SICEEP PPP - Response to Public Submissions

**DARLING HARBOUR LIVE**

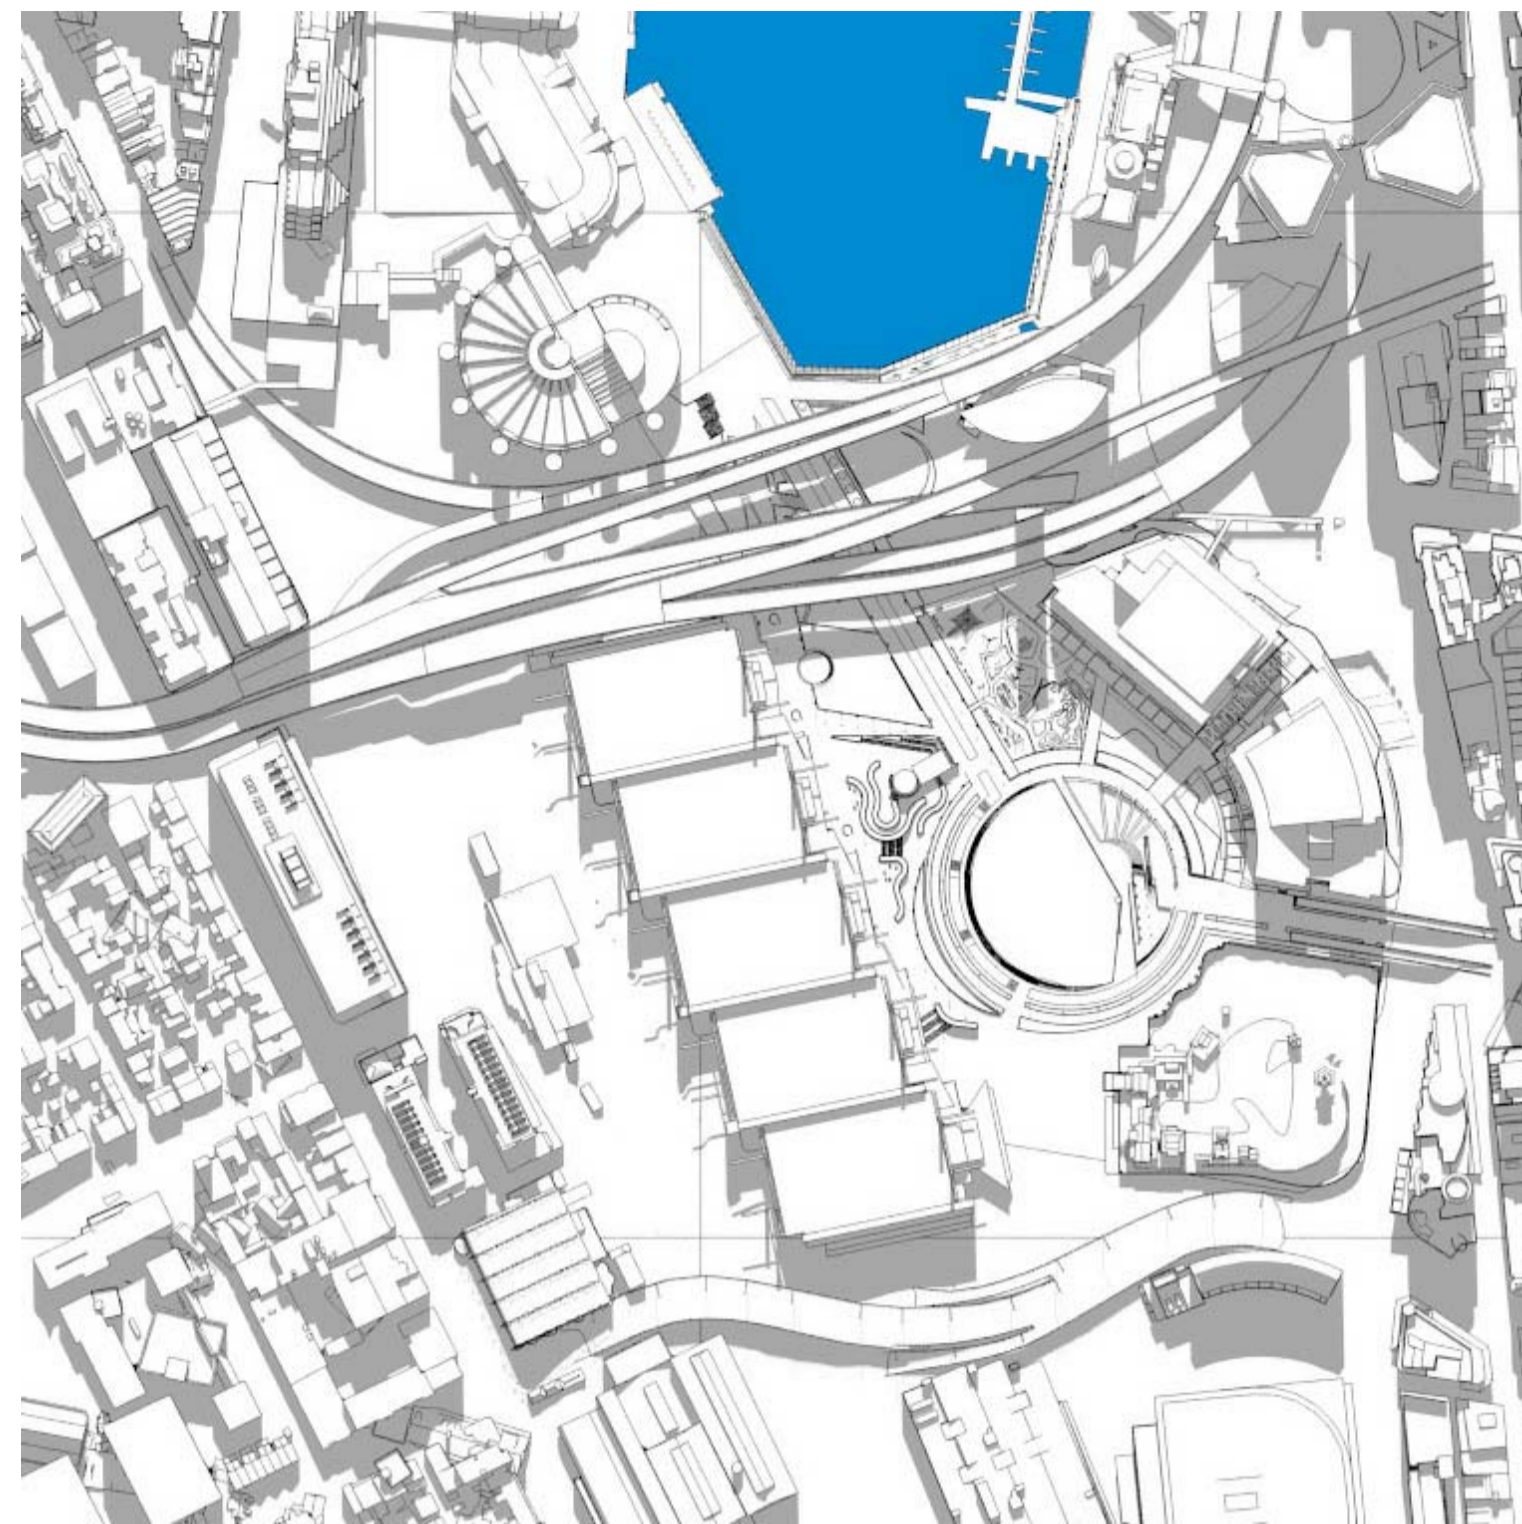
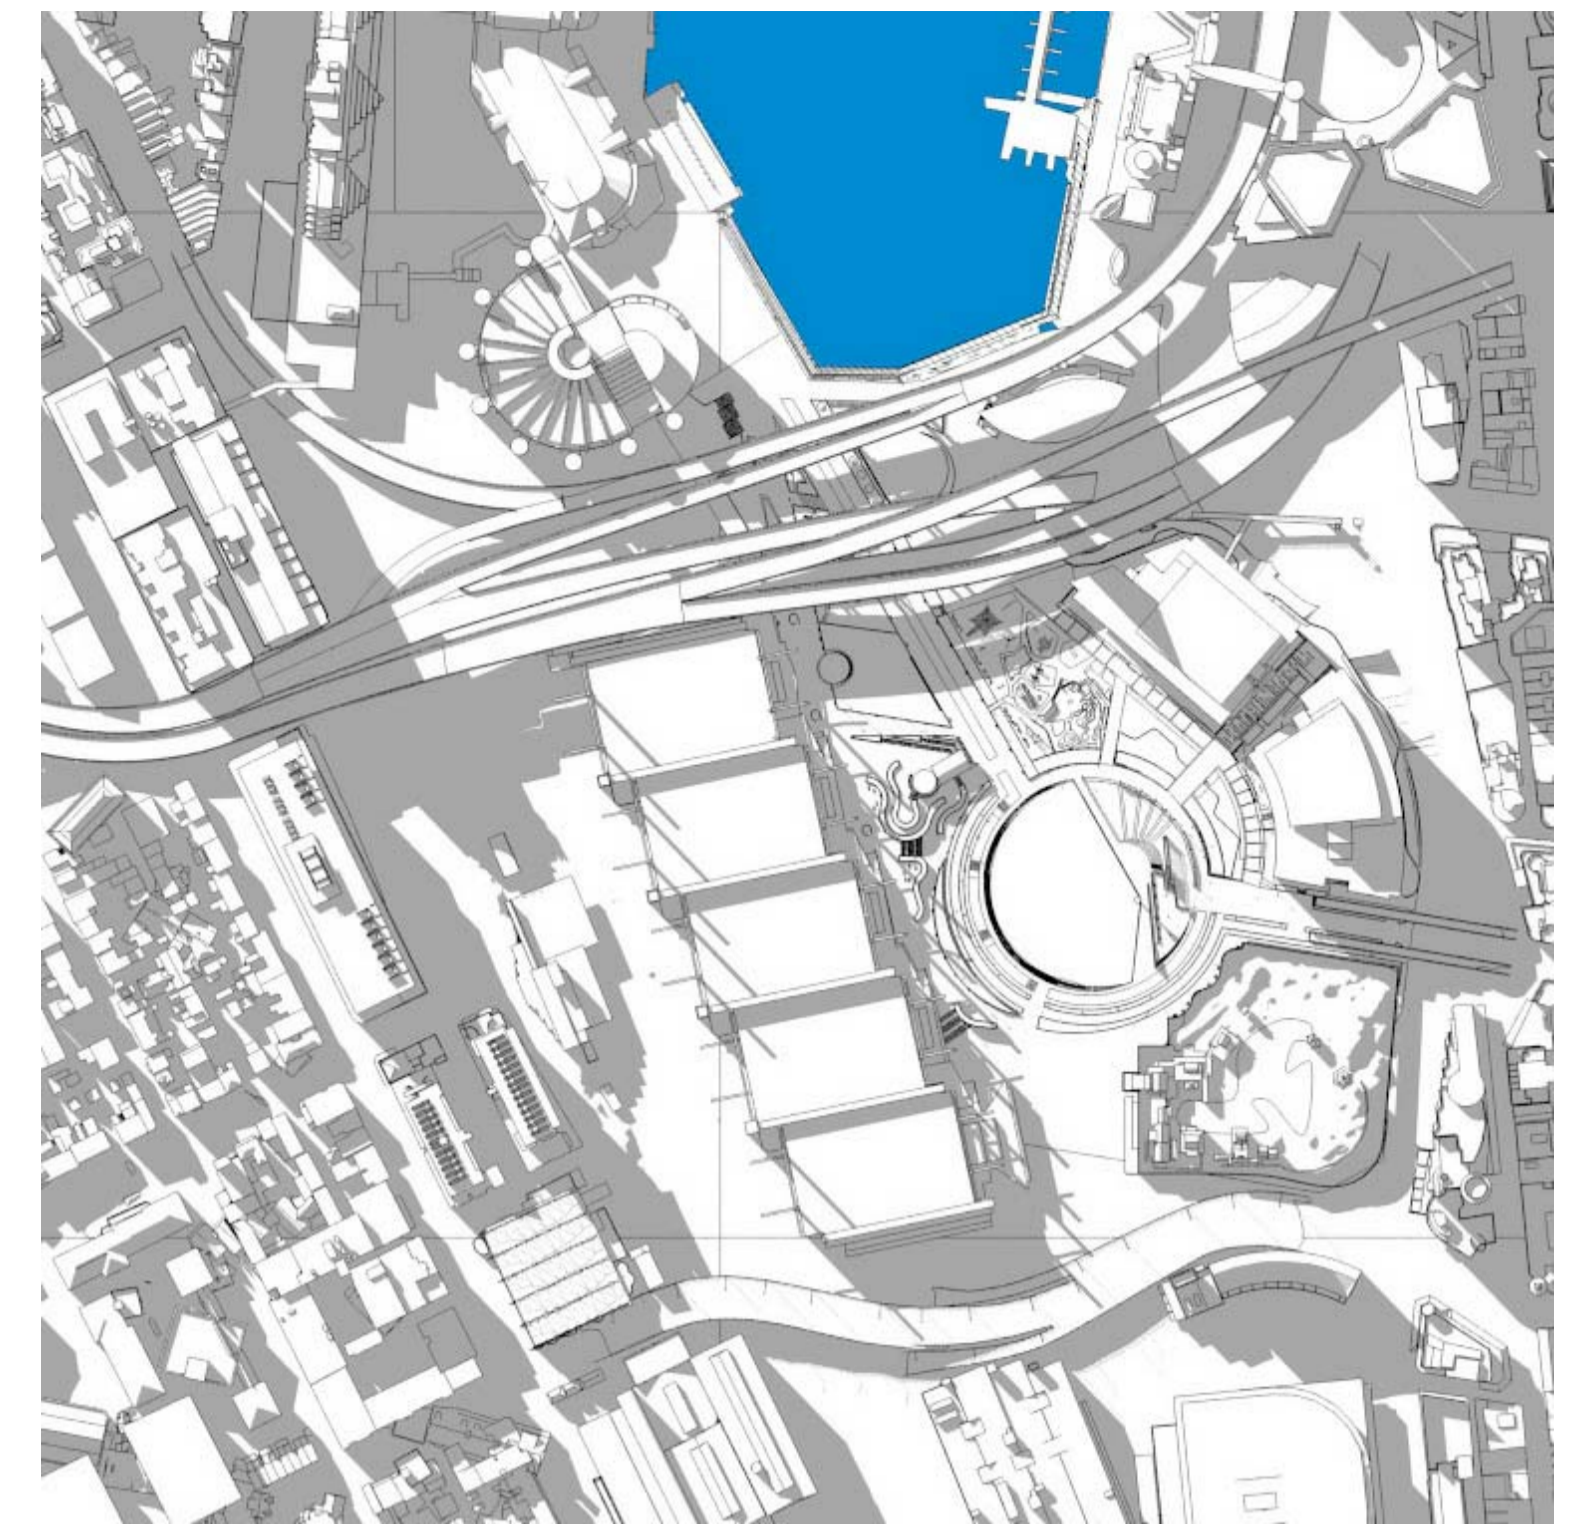
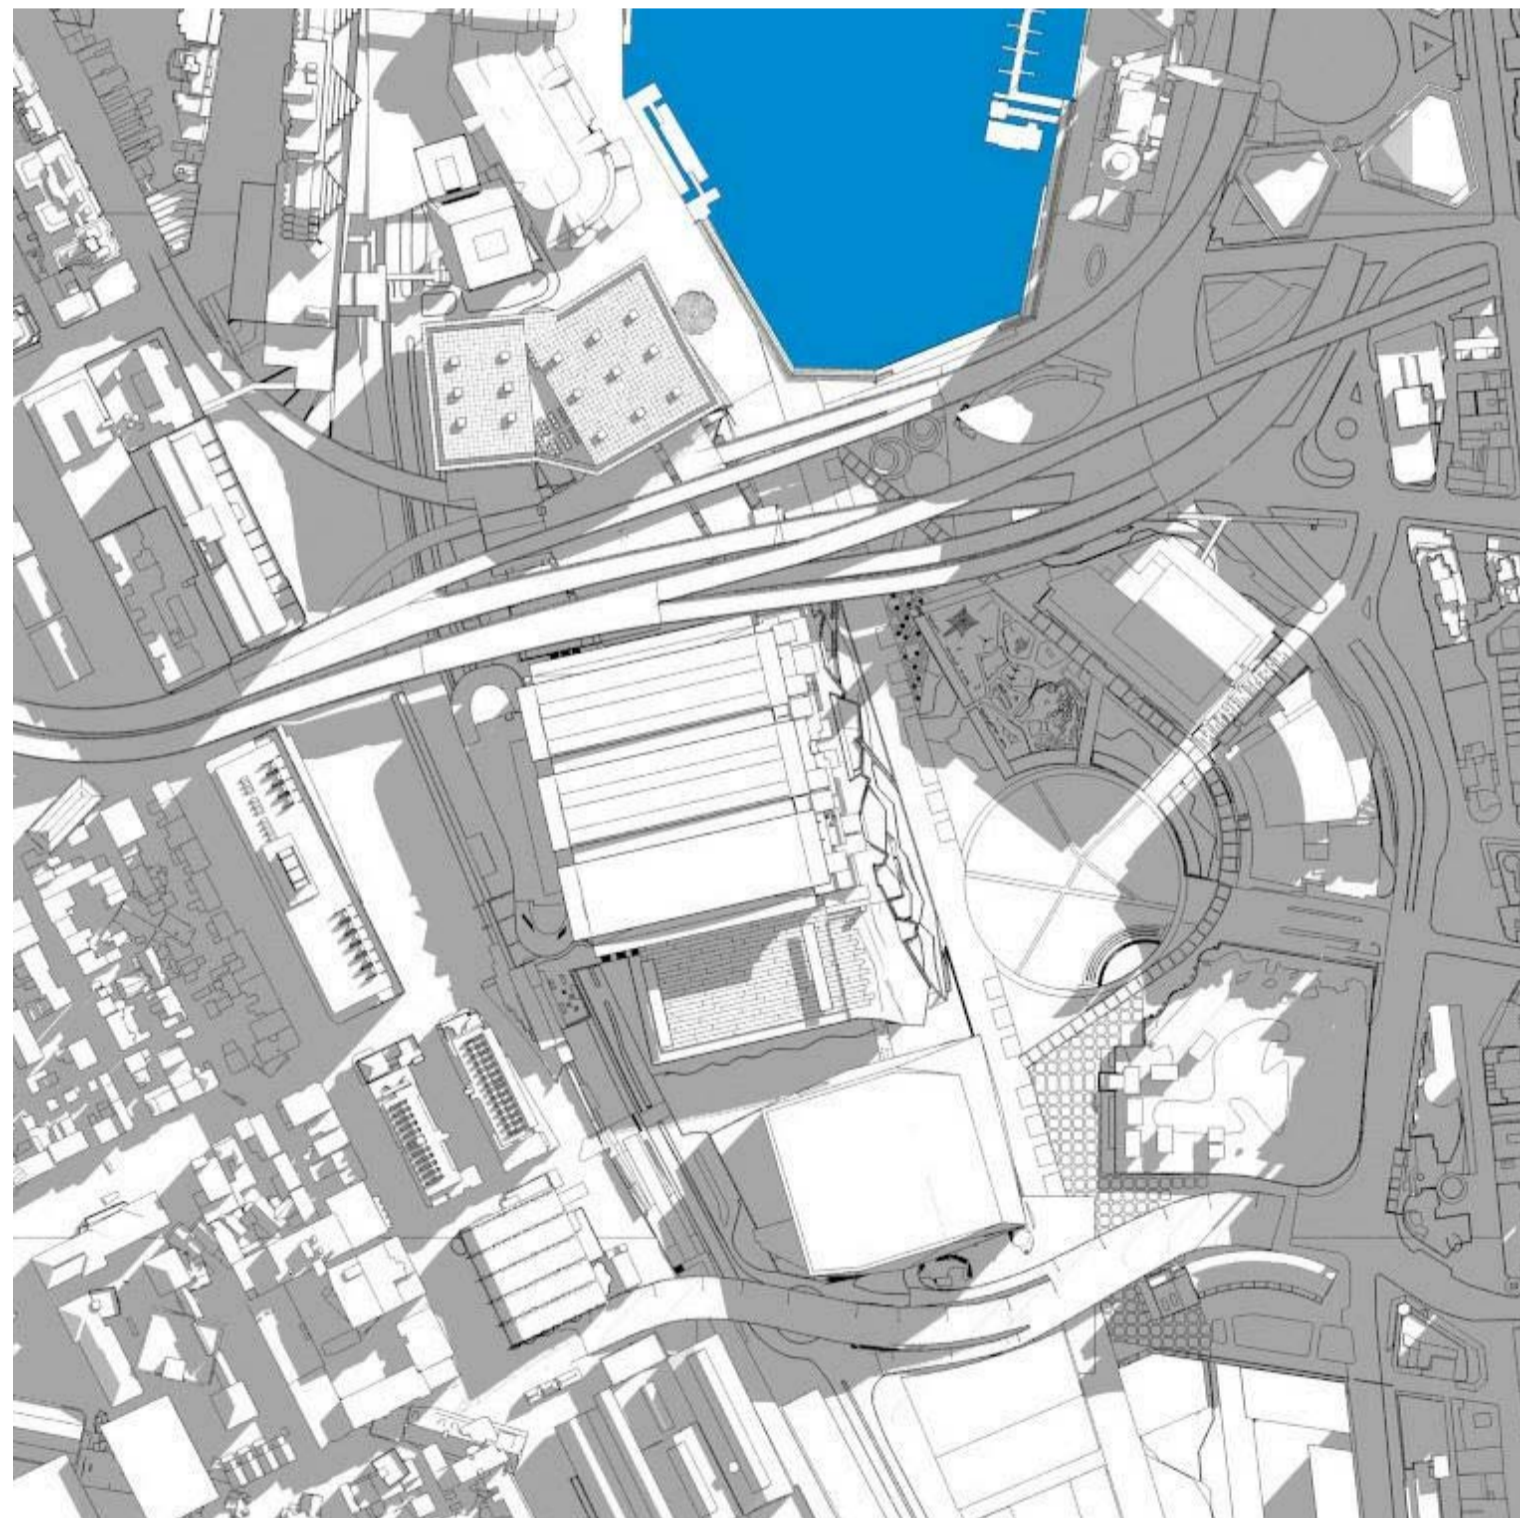
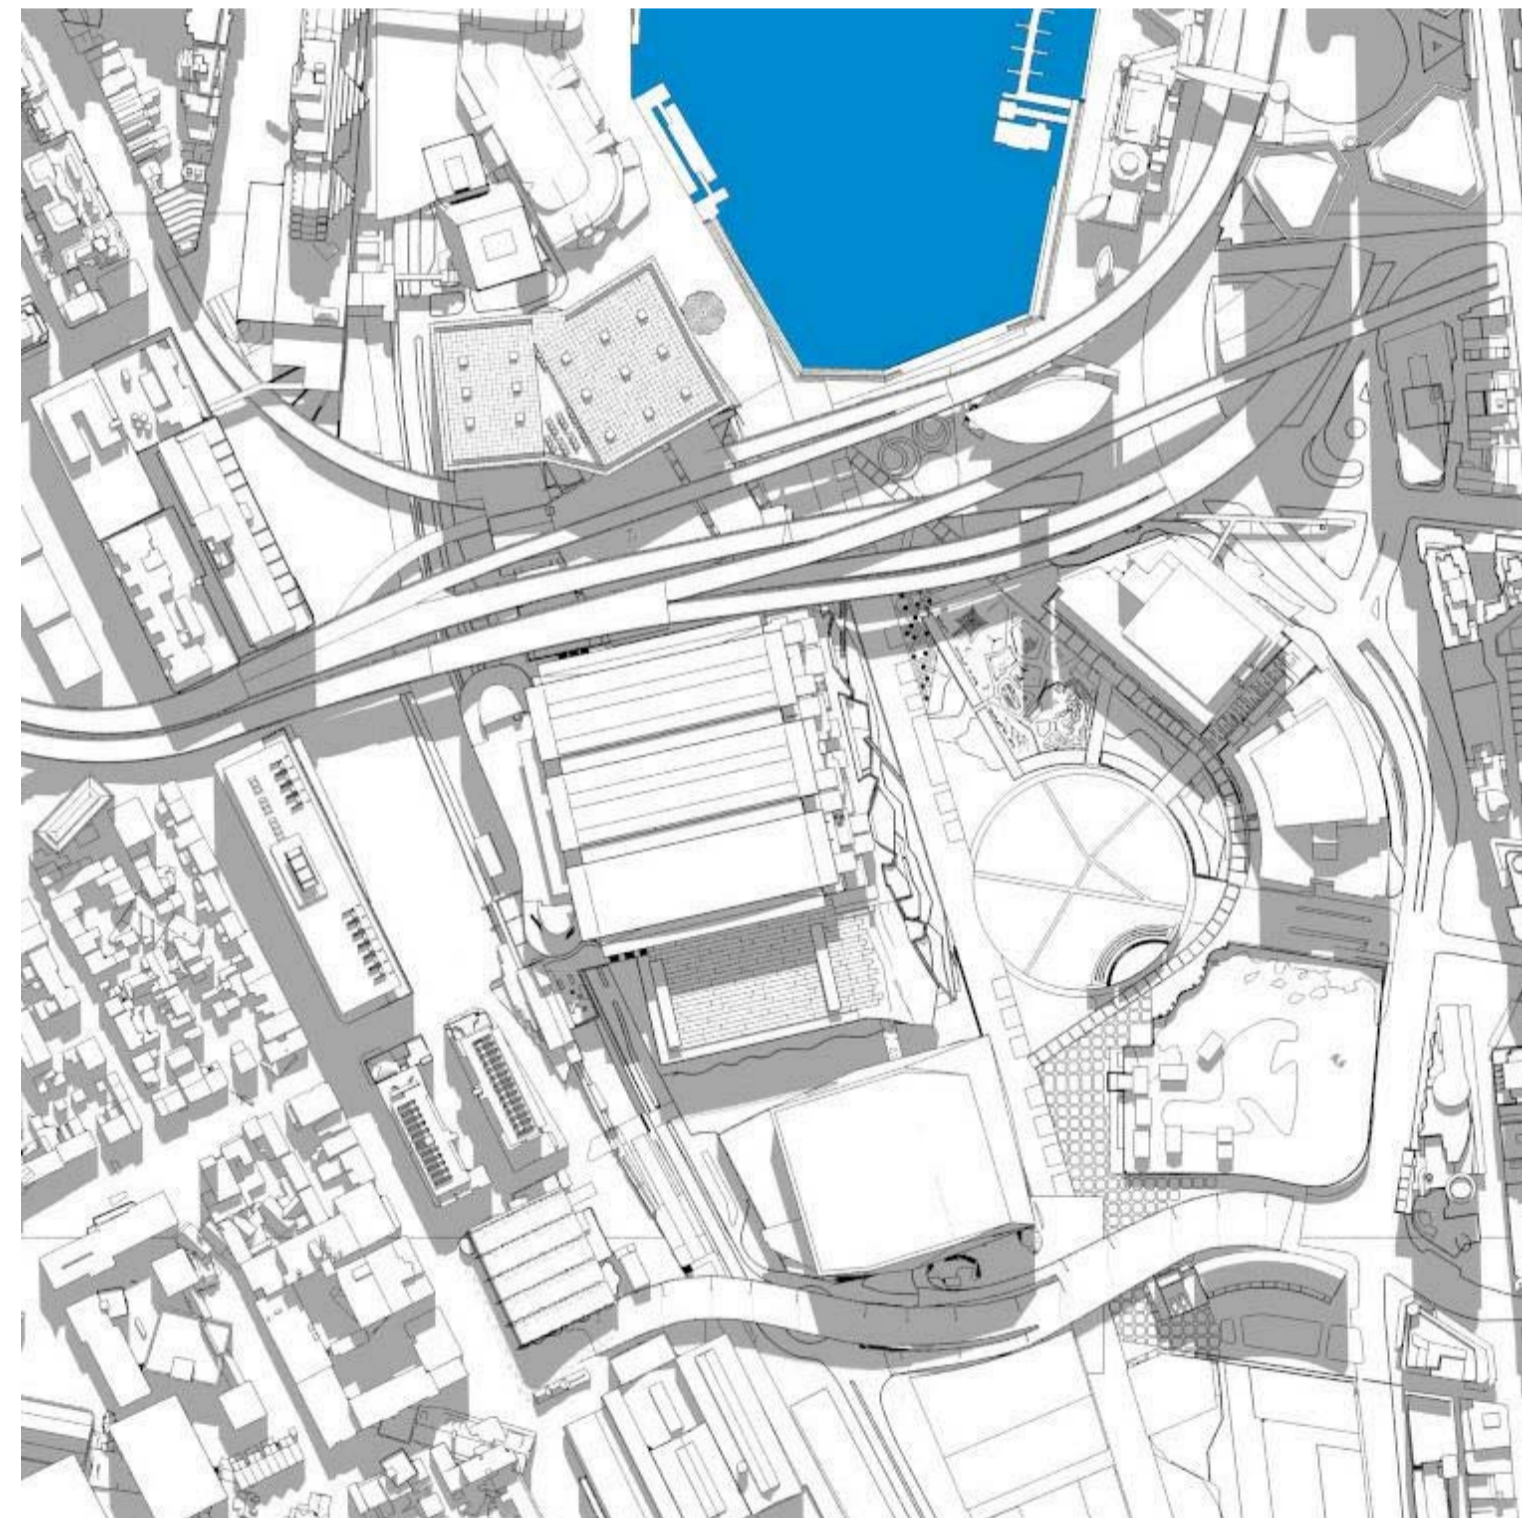
8	Unacceptable level of overshadowing on public open space	At the winter solstice on 21 June (i.e. the worst-case scenario for overshadowing), the buildings proposed under SSDA1 will not overshadow Tumbalong Park between 9am and 3pm, and there would be only minimal overshadowing of the Chinese Garden of Friendship forecourt (there would be no overshadowing of the garden itself). At 3pm on 21 June there would only be partial overshadowing of the north-south boulevard during the worst-case scenario of 3pm. In light of the above, it is considered that the proposed PPP Site redevelopment will not result in any adverse impacts upon amenity within the adjoining public domain as a result of the proposed development.
4	Reduced amenity of public open space through removal of water features	As part of the Darling Harbour Live vision the Public Realm is a series of interactive water features for children of a variety of ages which combine to create a connected urban stream from south to north, along the Boulevard and terminating at the Harbour's edge. The removal of the existing water features will improve pedestrian permeability and provide a more interactive experience for visitors to the precinct. The Woodward Fountain, which is going to be listed on the State Heritage Register, will be retained as part of the proposed development, with the revised scheme seeking to increase the curtilage between the ICC and the water feature.
